Stormwater MHFD Calculation comments.pdf Markup Summary

STORAGE TABLE BUILDER
ver 4.07 (June 2017)

DETENTION BASIN STAGE-STORAGE TABLE BUILDER

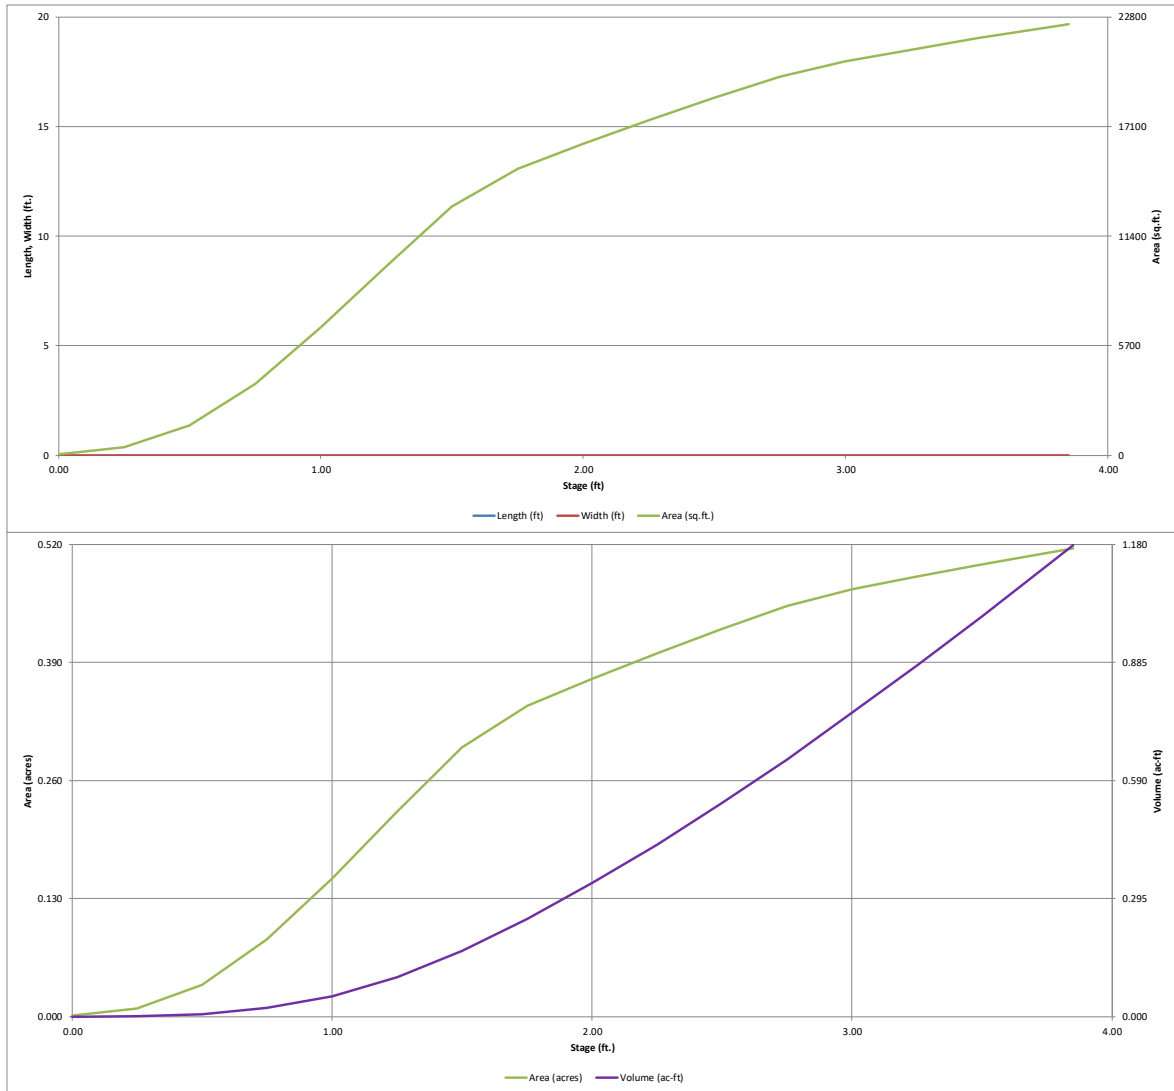
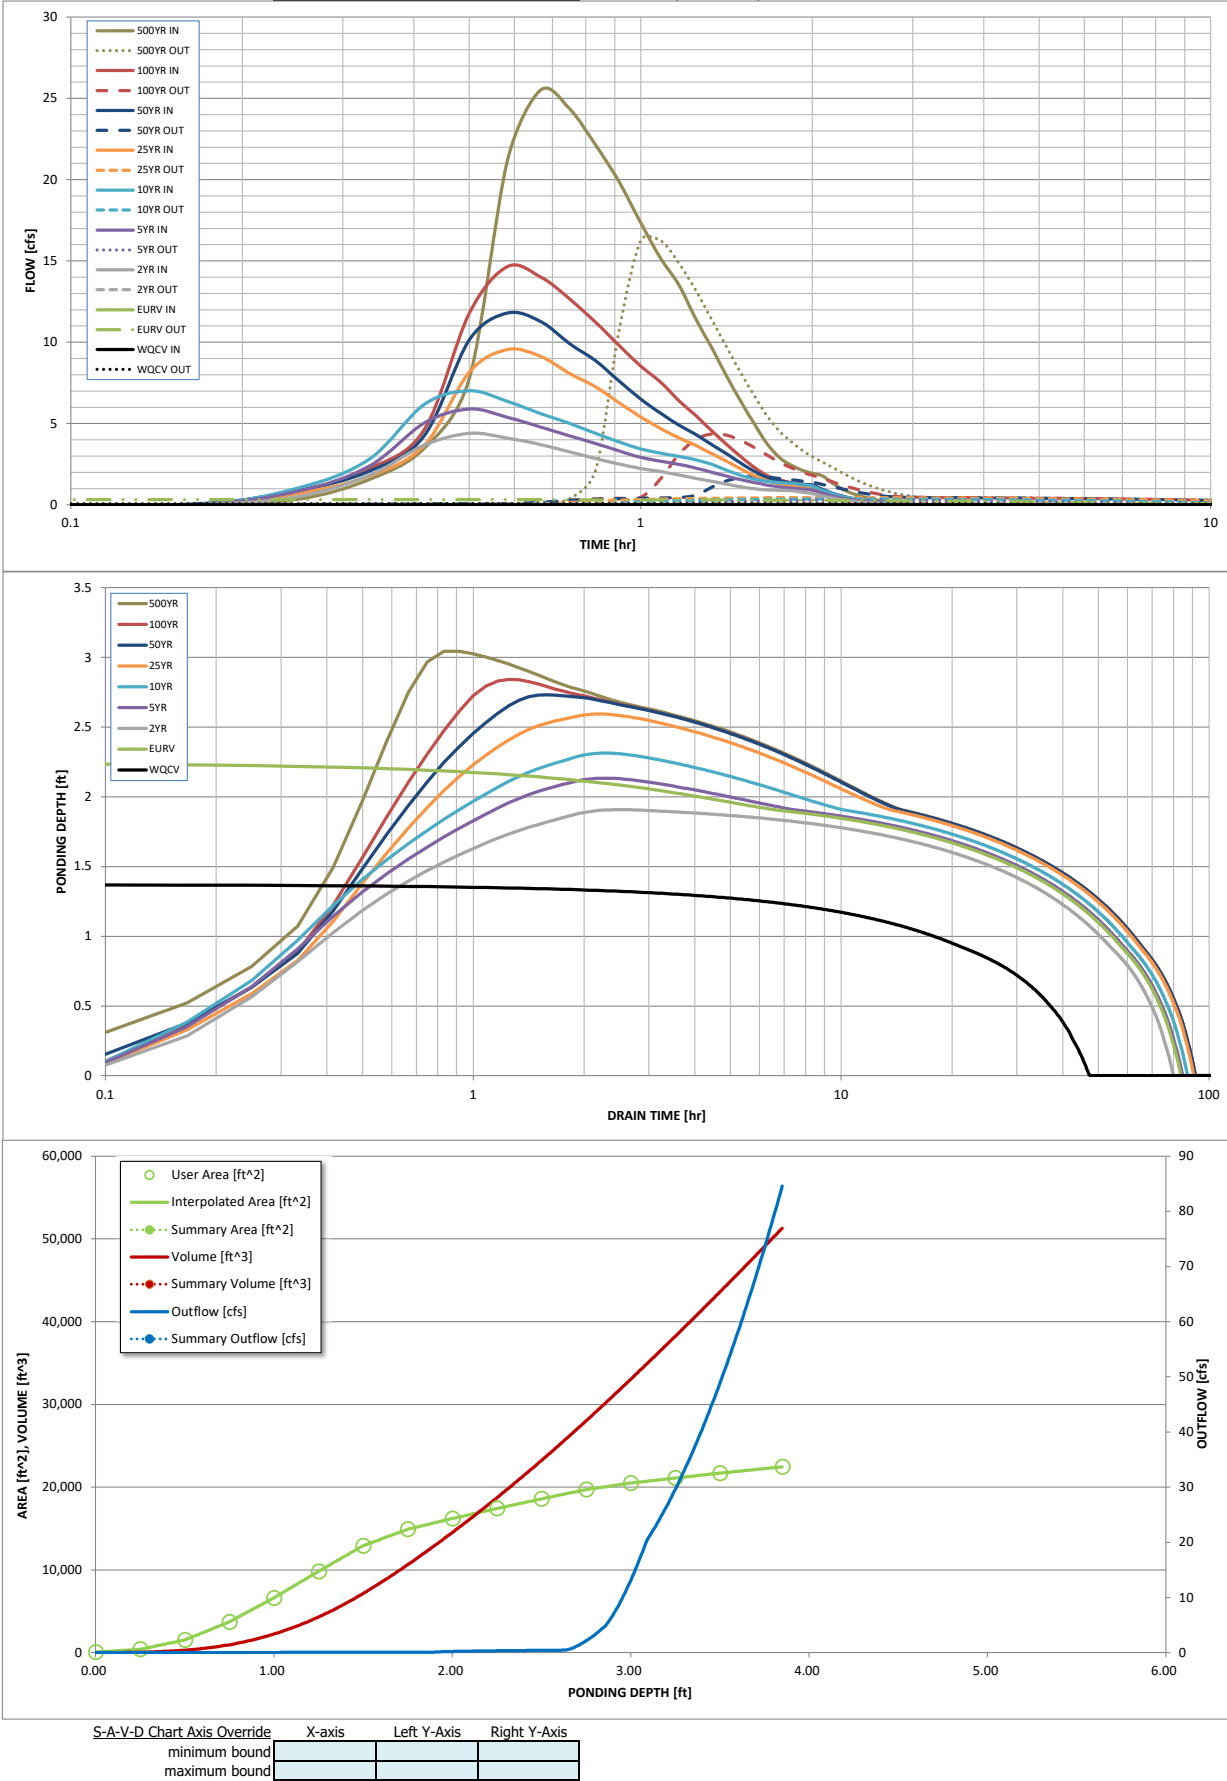
See comments on calculations in drainage report

See comments on calculations in drainage report

The CUHP values are being used on the MHFD Detention calculations instead of being overridden using rational. Updates have been made to the orifice plate in order to meet requirements. The slope has been changed to 4:1 matching other documents.
